22 August 2019

**RE: SSD 9670 Response to Submissions  
Western Sydney University Innovation Hub, 2-6 Hassall Street, Parramatta**

1 SERVICES PLAN - PD HASSALL STREET  
1:200

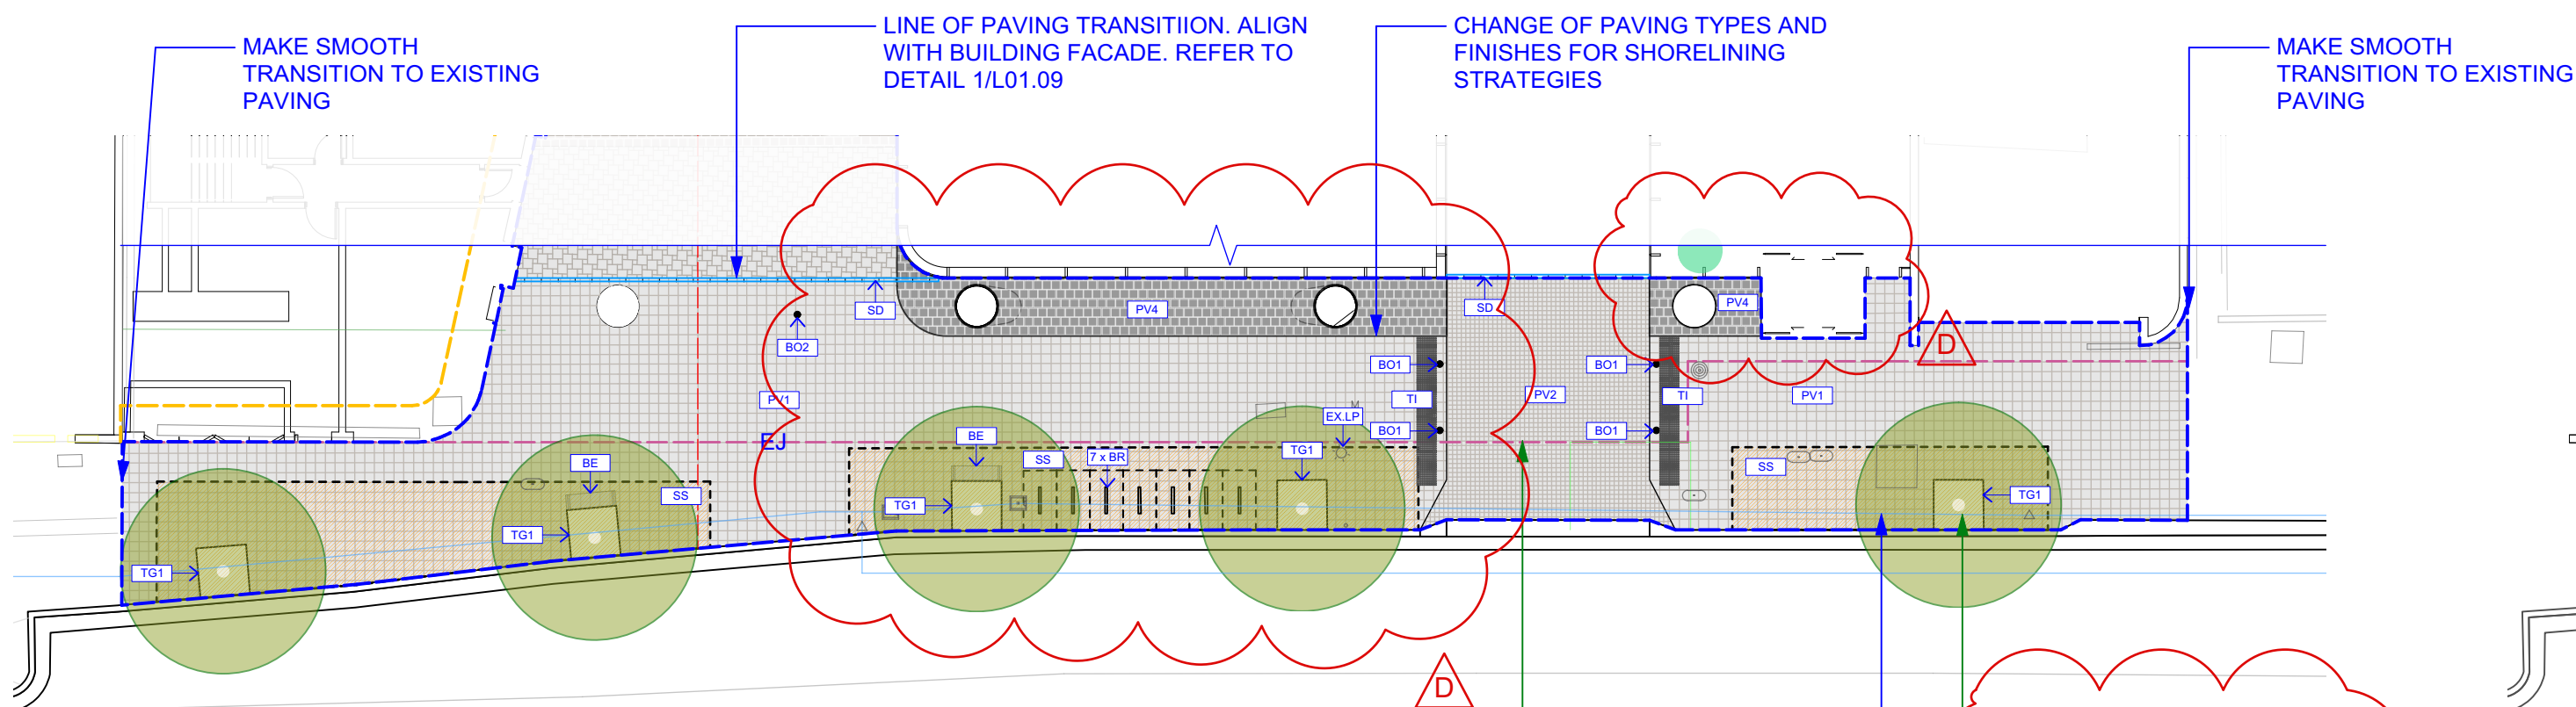
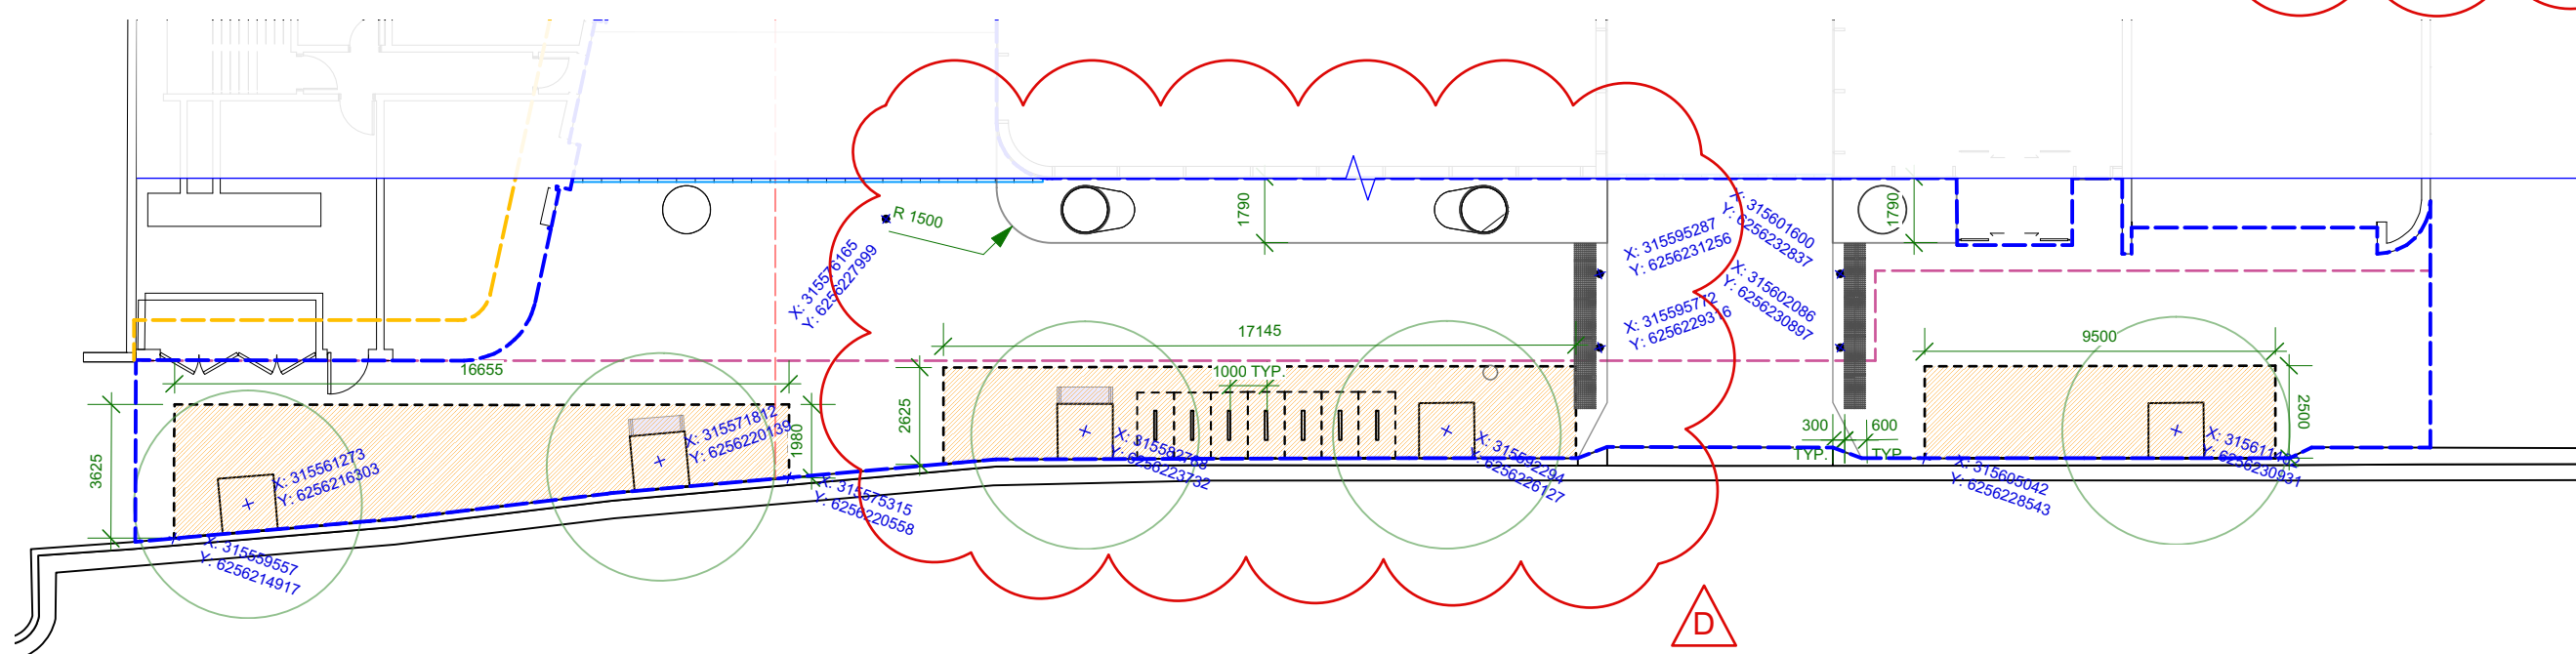
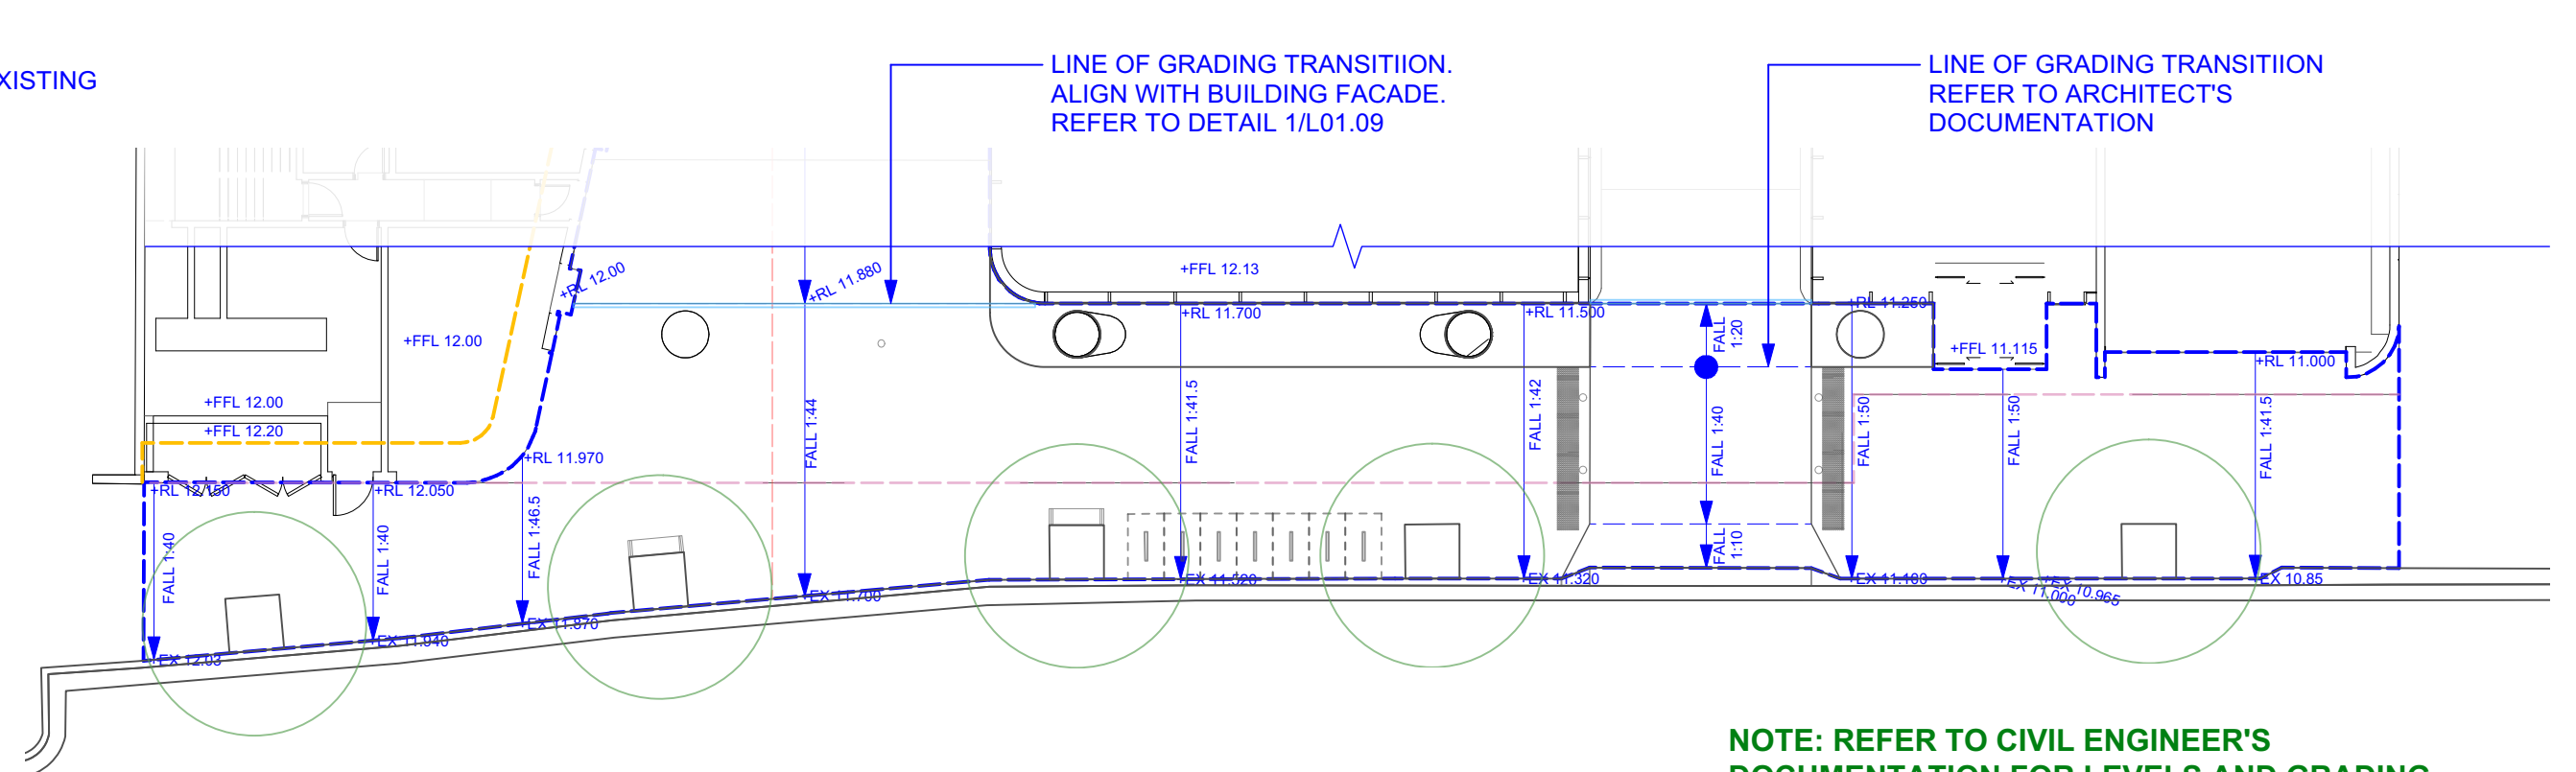
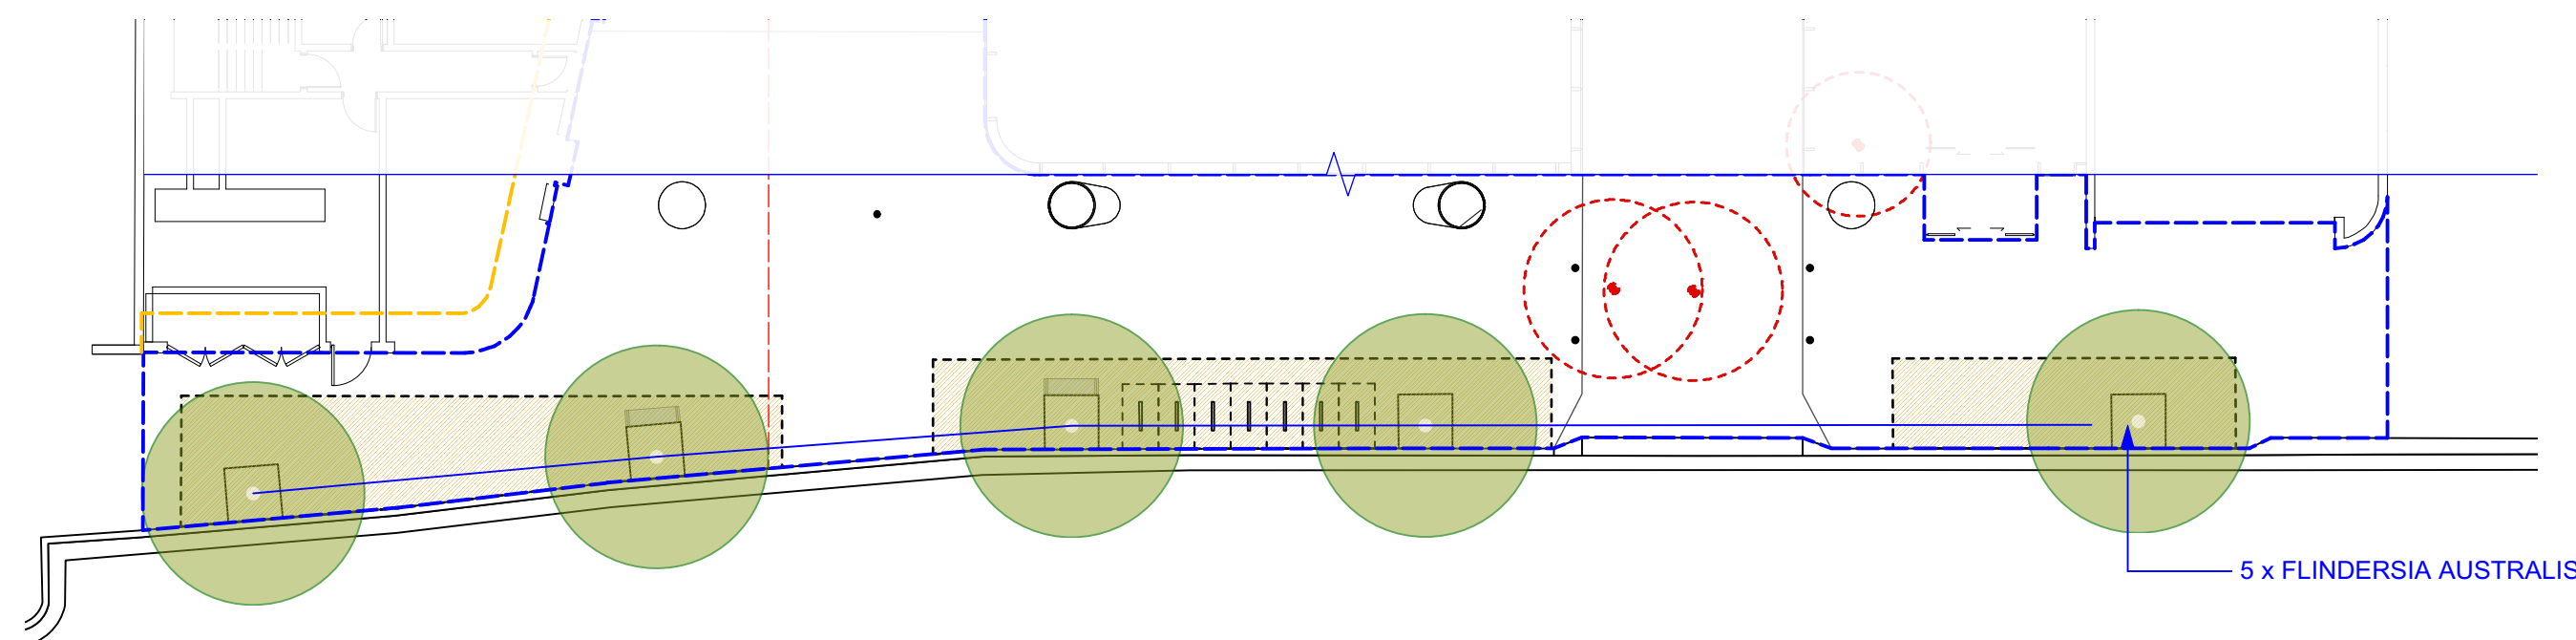
Council has commented in their submission that the Hassall Street frontage presents a lack of activation through the combination of a driveway and a substation and the presence of a lab. Council recommends that a redesign is considered to present better activation.

The applicant does not agree with this comment, with particular reference to the GANSW Design Competition Jury Report and Design Integrity Report which clearly notes a key feature of the proposal which contributes to design excellence being the proposal's Hassall Street presentation and the activation it provides by effectively extending the public domain and pedestrian activity through the site. Specifically, as noted in the EIS:

With regard to the driveway and substation, they have been located in the most logical position considering the site's constraints. In particular, the site has a single road frontage, therefore Hassall Street is the only opportunity for vehicular entry. In addition, the substation has been located at ground level fronting Hassall Street to comply with Endeavour Energy's access requirements.
